WELWYN HATFIELD COUNCIL – DEVELOPMENT CONTROL
DELEGATED REPORT

APPLICATION No:	S6/2010/2735/FP
------------------------	------------------------

DESCRIPTION OF PROPOSAL:

DRAWING NUMBER
PL-2000

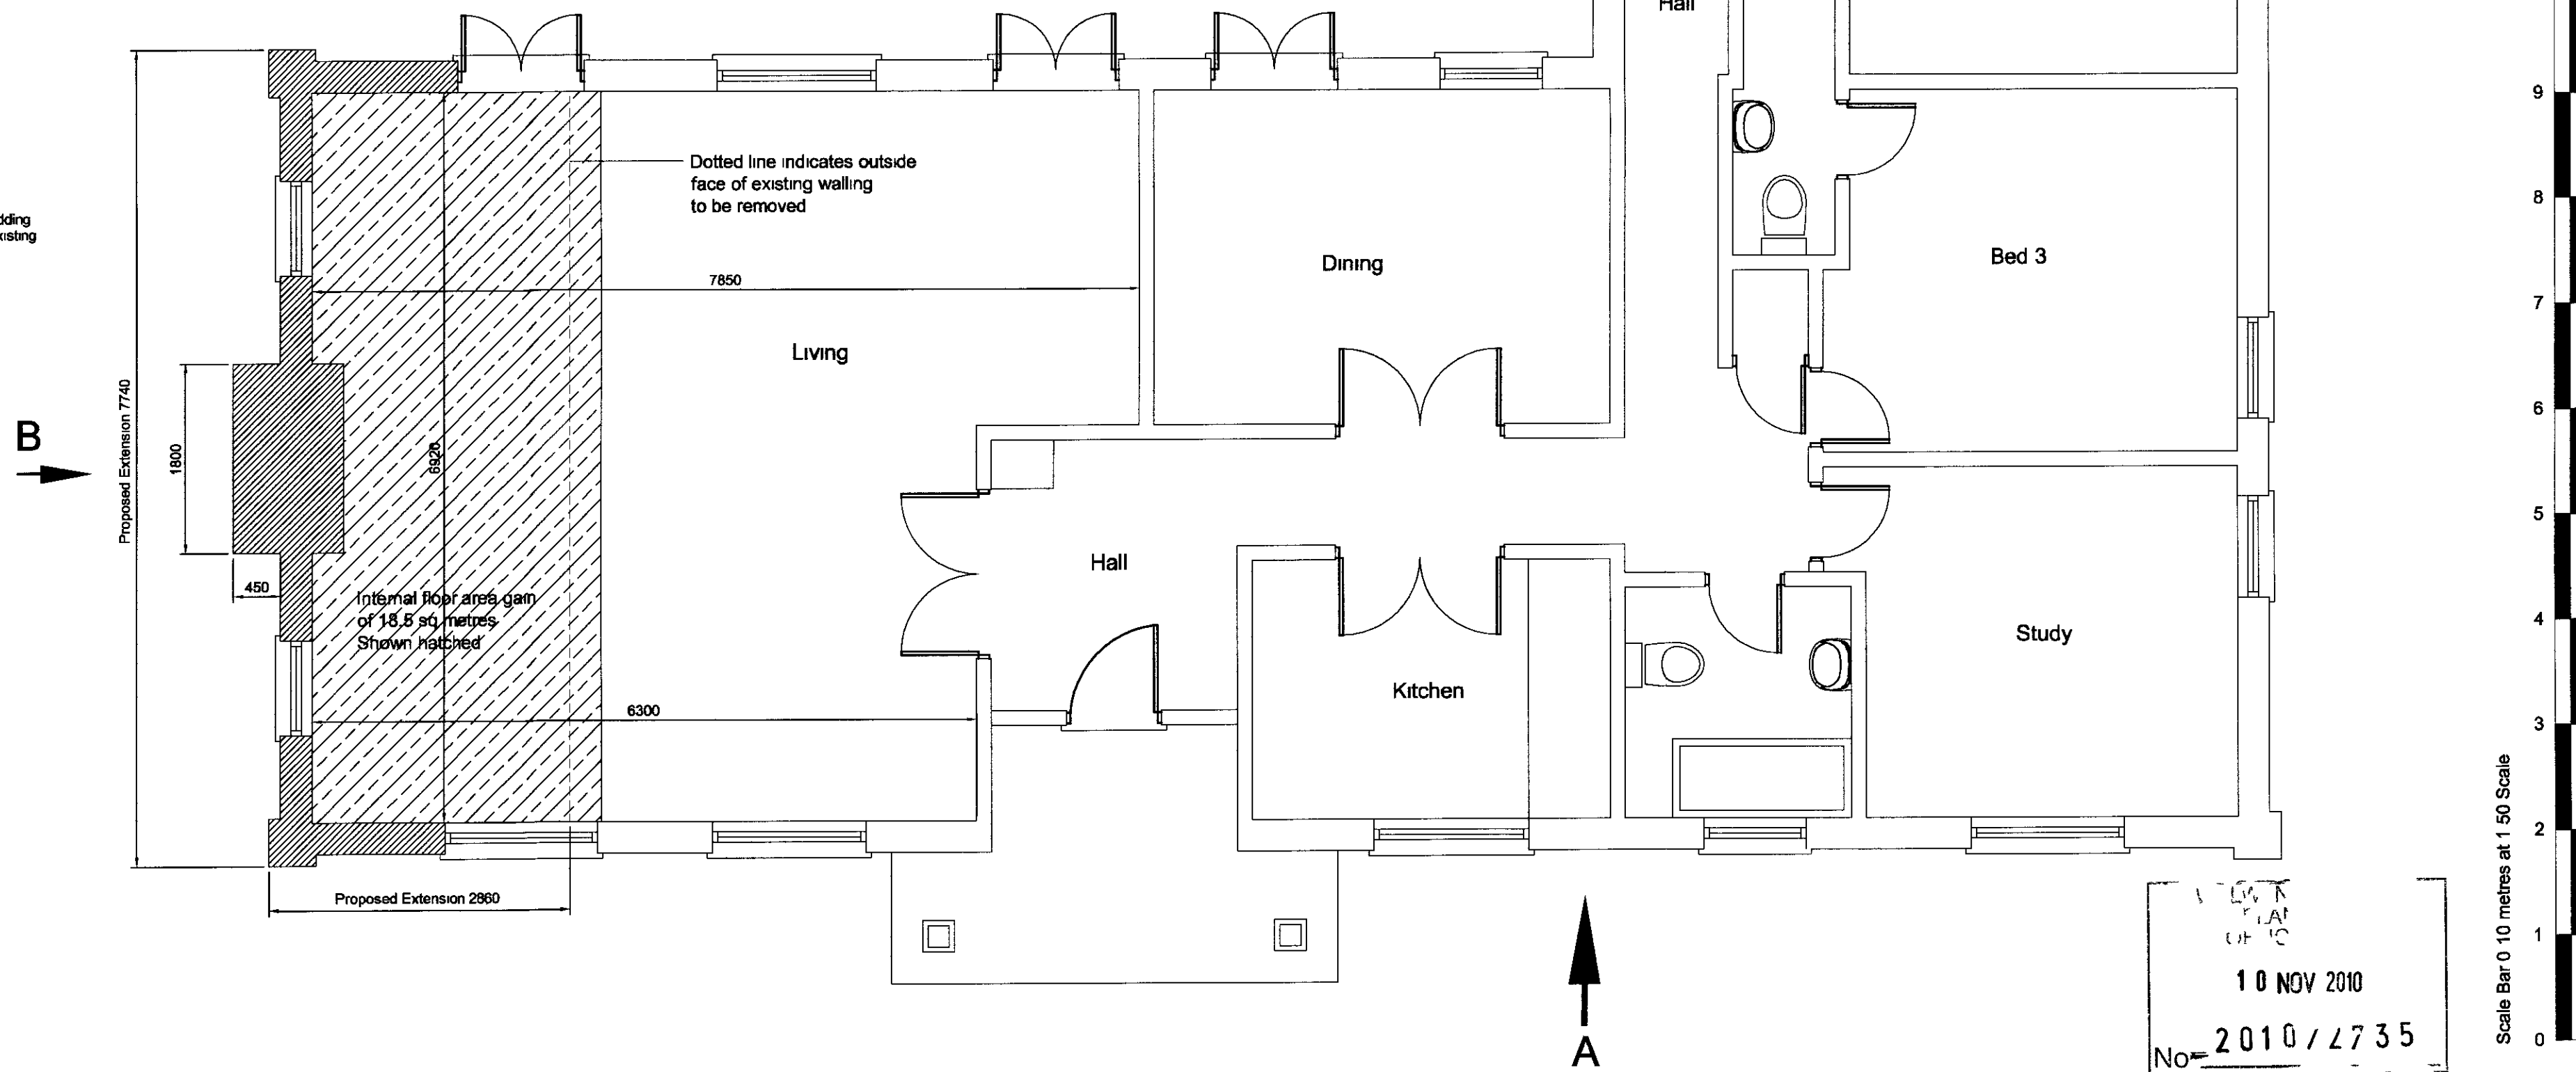
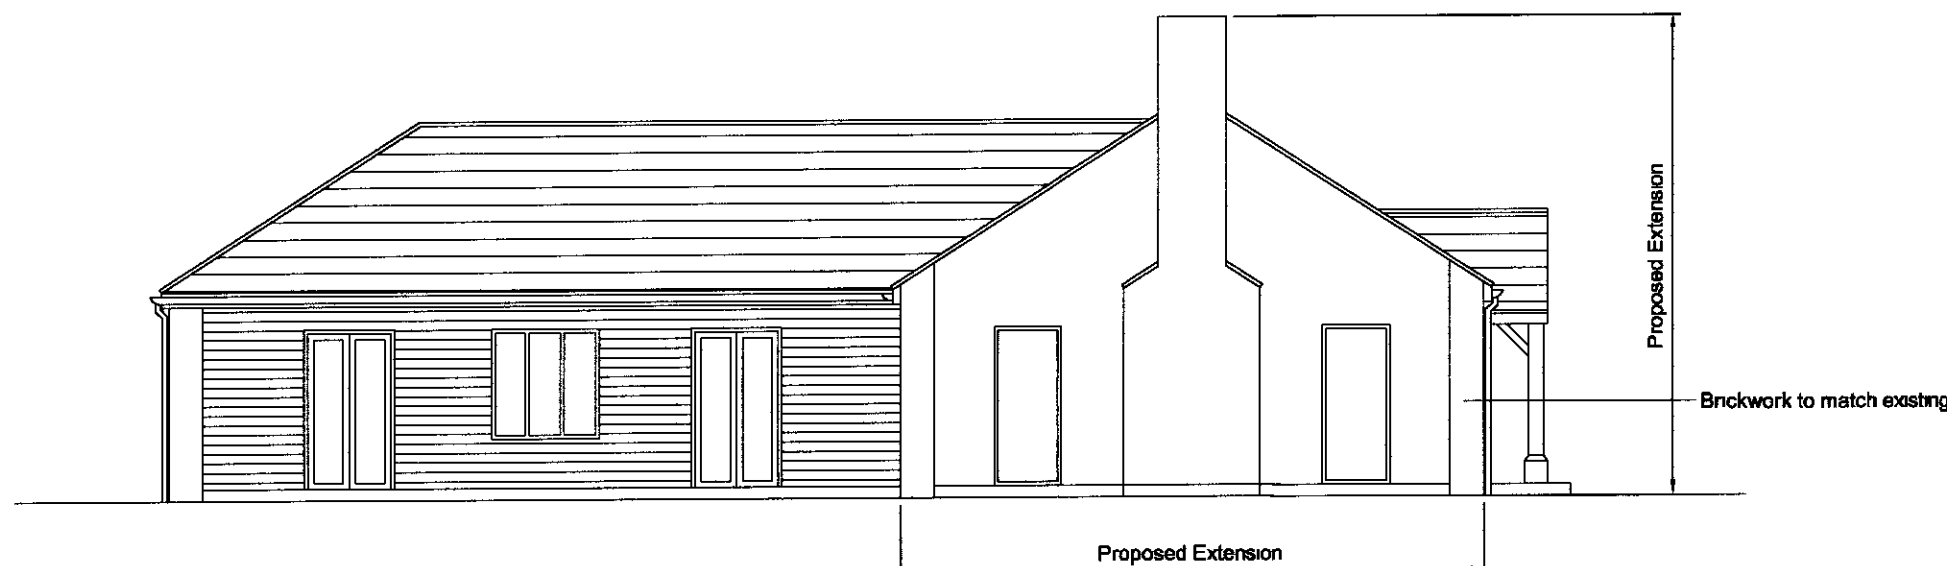
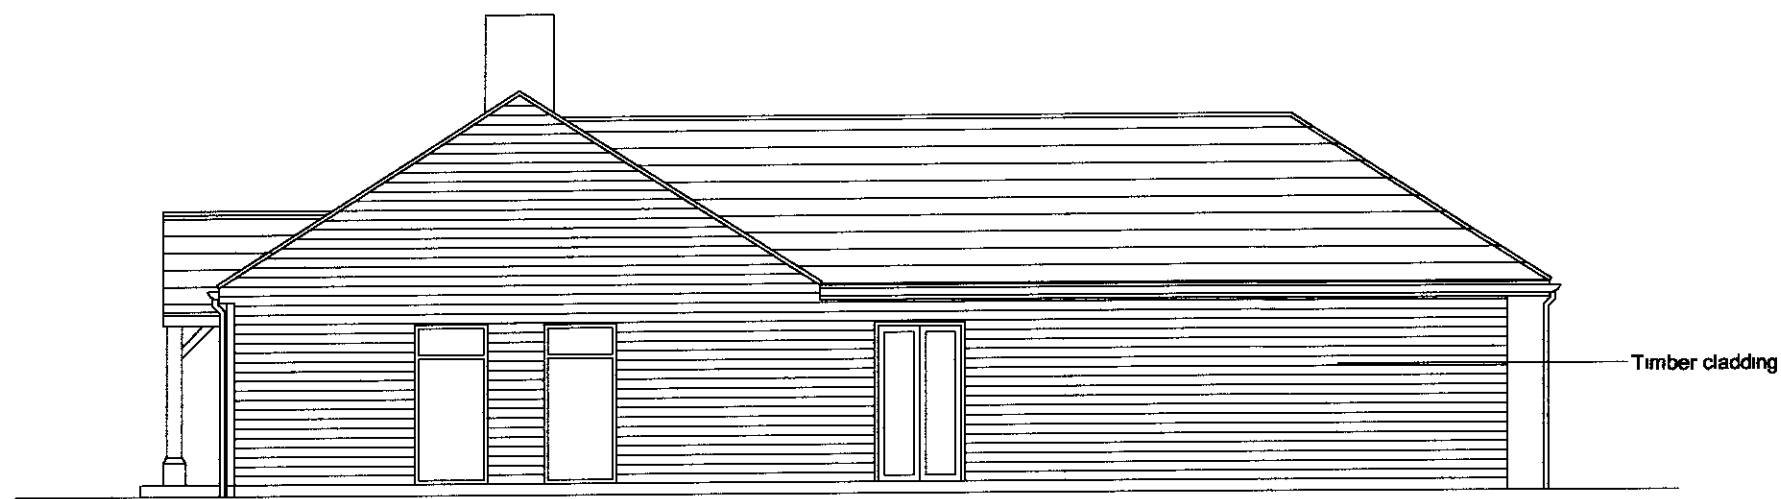
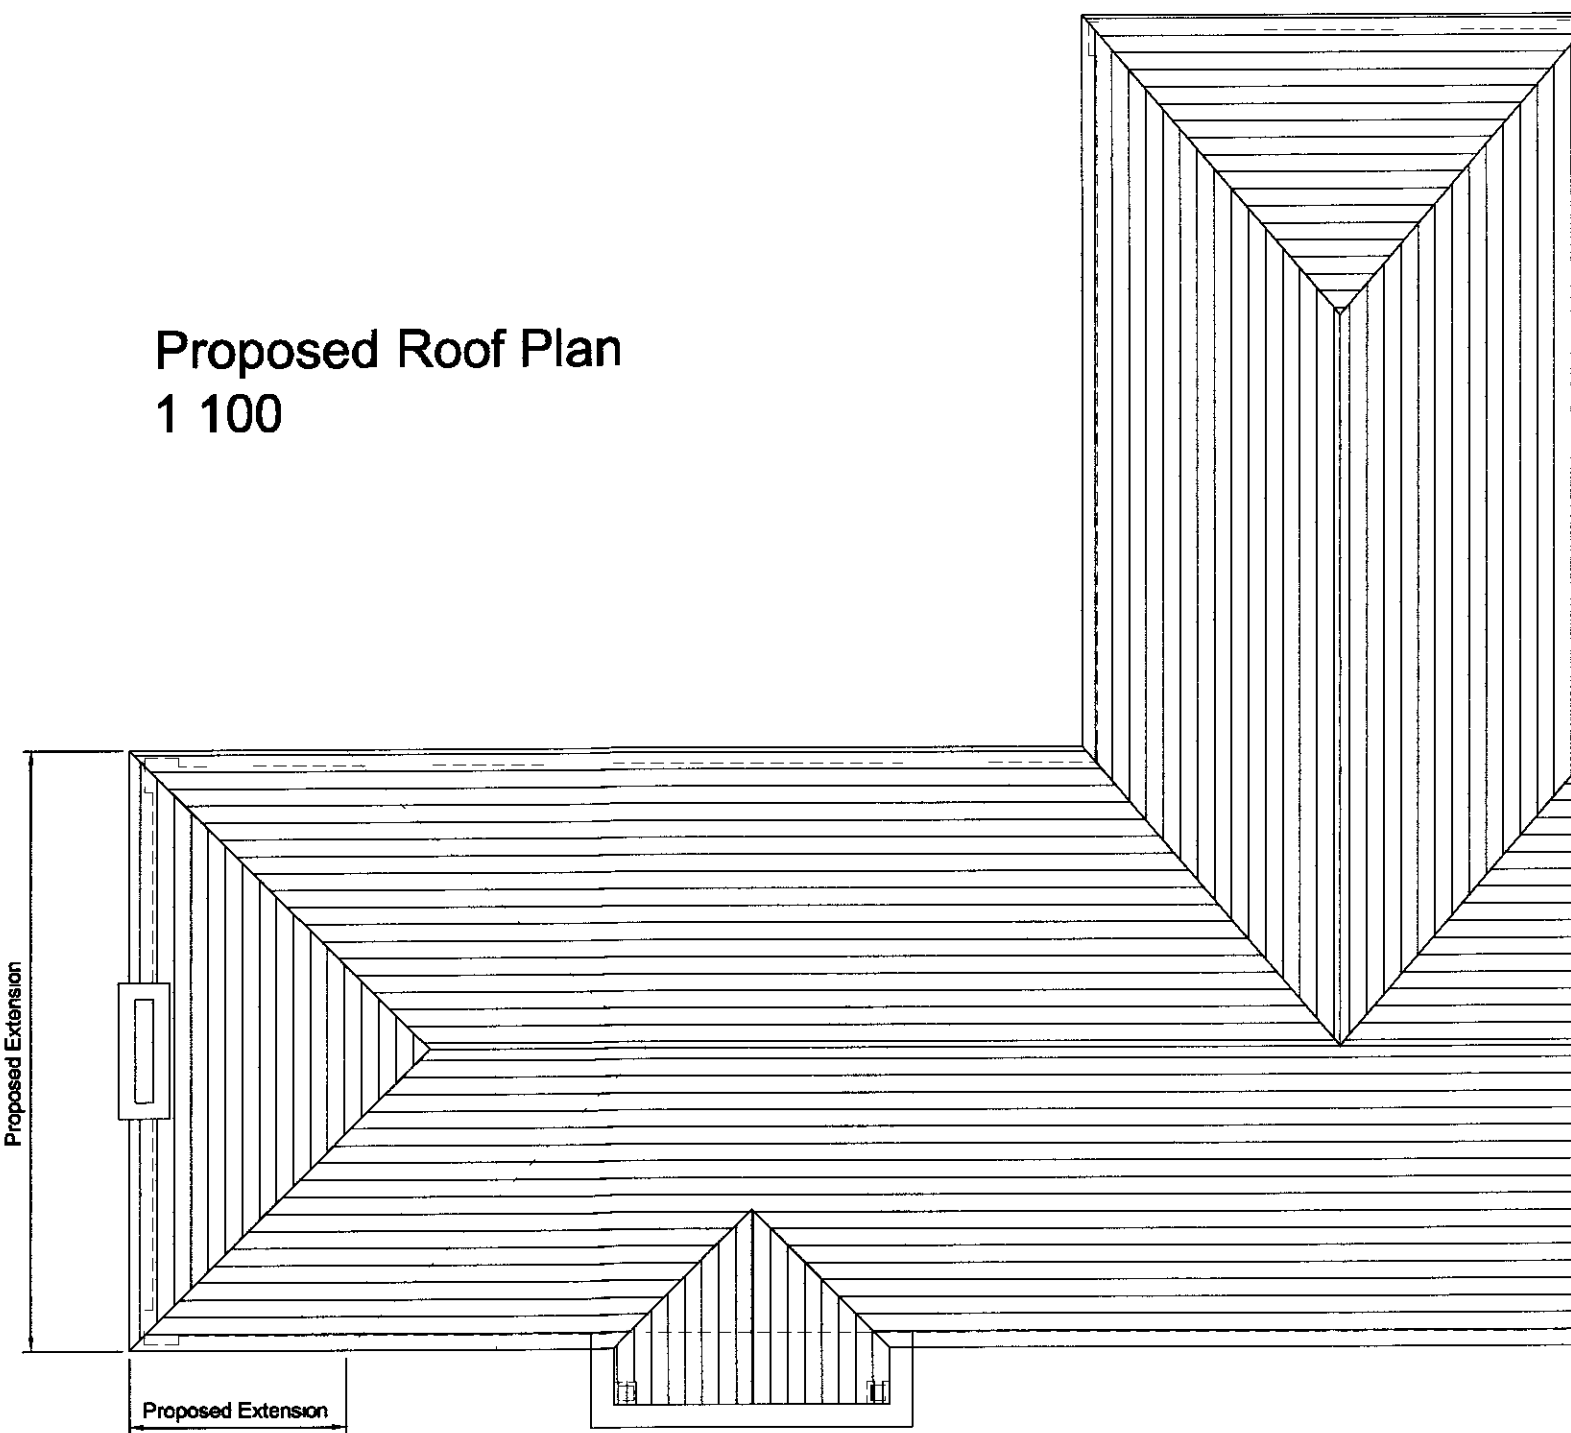
The proposed development would involve an extension to the northern flank wall of the dwelling. The proposal would measure 7.74m in depth by 2.86m in width and would adjoin the main roof to create a gable end with a new chimney.

The application dwelling has been previously extended significantly, with an extension which has added roughly 63sq.m. The original dwelling had a floorspace of 116sq.m and therefore the property's floorspace has been increased by approximately 54% as existing. The proposed development would have a floor area of 22.1sq.m and the resultant dwelling would have a floorspace of 202.5sq.m. Therefore, the resultant increase in floorspace would equate to 74.6% when compared to the original dwelling.

The original modest 3 bedroom property has been extended to have much larger accommodation and the additional bulk and massing of the proposed extension would result in a far larger property. The cumulative extensions to the property would result in a disproportionate increase in the size of the dwelling, which cannot be described as limited extensions. The resultant dwelling would affect the openness and increase the urbanising impact upon rural character of the Green Belt.

When viewed individually the proposed extension's projection and floor area would be subordinate in scale and would attach well of the existing dwelling. Although, the proposed chimney and gable end would add significantly to the bulk and mass of the

dwelling and this would be a large increase when compared to the original dwelling. From a design point of view the resultant dwelling would not be significantly more harmful than the existing dwelling. Due to the siting of the dwelling the proposed extensions would not be viewed prominently or appear dominant from the surrounding public areas and the resultant dwelling would not have a significantly greater impact upon the visual amenity of the area. Therefore, although the proposal would increase the bulk and massing of the property which conflicts with Policy RA3(i), the appearance and quality of design and appearance of the proposal would not conflict with the requirements of design Polices D1 and D2 of the Welwyn Hatfield District Plan 2005.

1. The proposal by virtue of its size, bulk and mass, when considered cumulatively with existing extensions, would result in disproportionate additions over and above the size of the original dwelling and therefore represents inappropriate development within the Green Belt. The applicant has failed to demonstrate to the satisfaction of the Local Planning Authority any very special circumstances exist to outweigh the harm caused by reason of its inappropriateness. The proposal is therefore contrary to PPG2 and Policy RA3 of the Welwyn Hatfield District Plan 2005.
